I am a current resident of Moat Hill Farm Drive

I see that there are two proposed self contained developments on the plan with entrances at the existing Clough House entrance on Leeds Road and also from Moat Hill Farm Drive. 23 properties will be accessed through Moat Hill Farm Drive and 7 from Leeds Road.

5.0 Movement

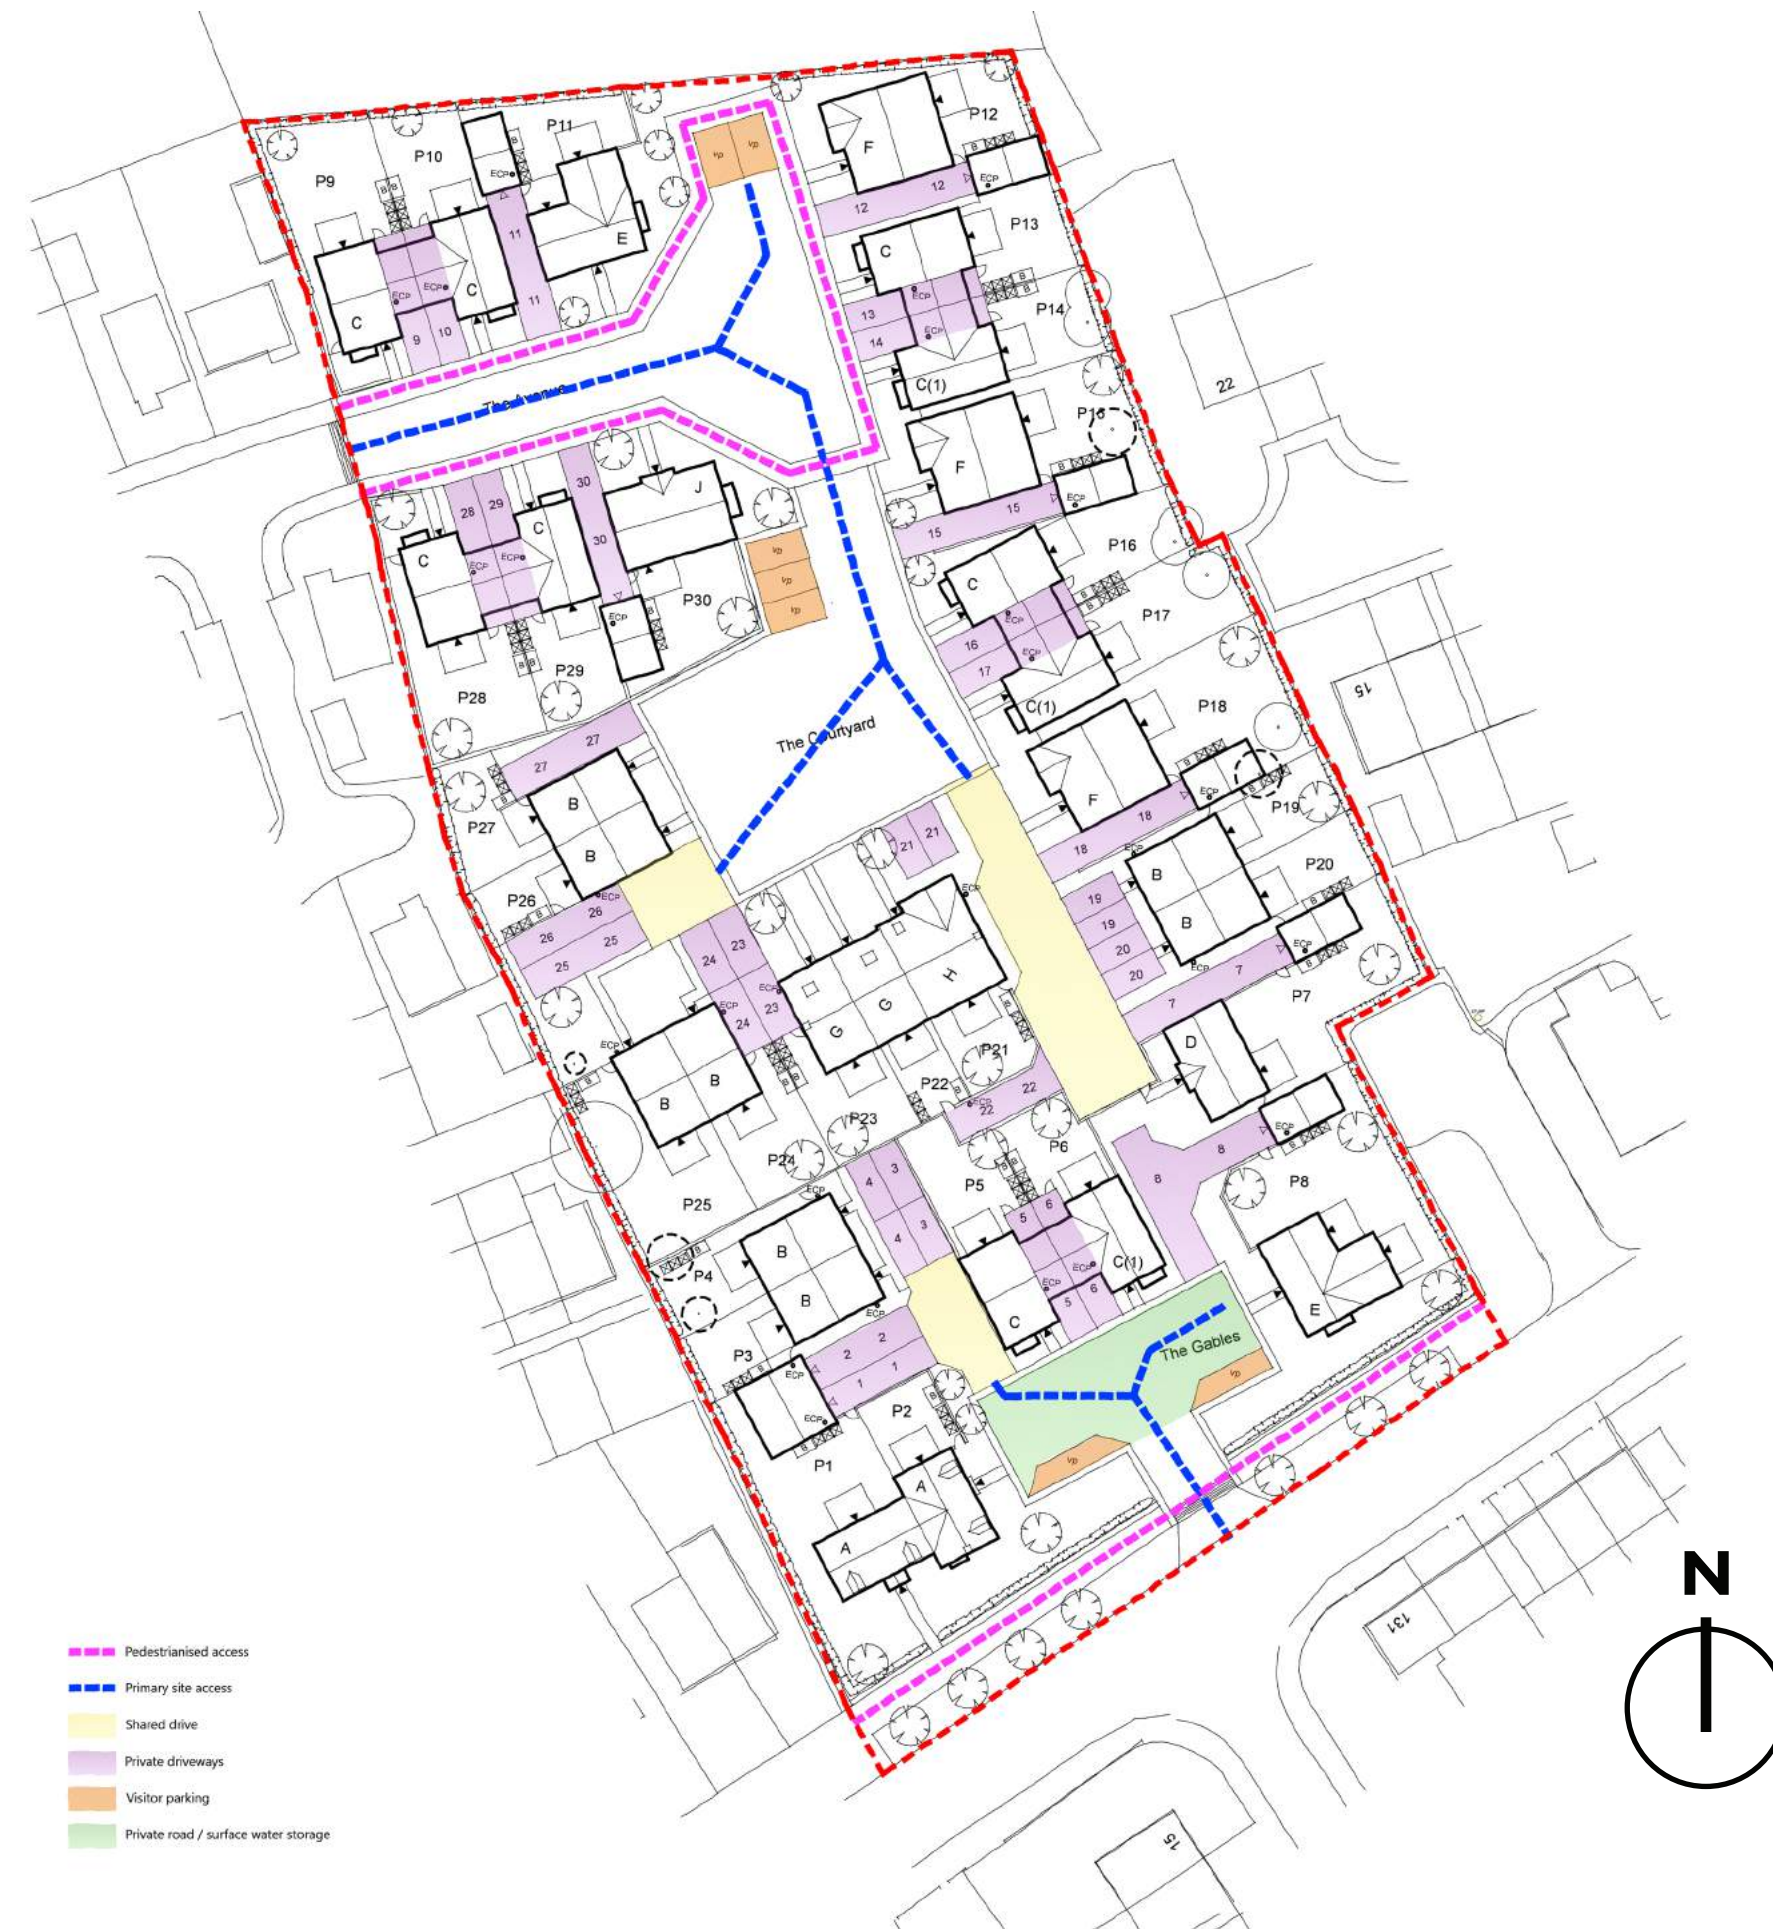
I strongly oppose that the majority of properties at the proposed development on Clough House should be accessed via Moat Hill Farm Drive and see no valid reason for this to be the case.

I am asking if a compromise could be struck whereby most of the access to the properties could be via Leeds Road i.e. access to 23 properties from Leeds Road and 7 properties via Moat Hill Farm Drive?
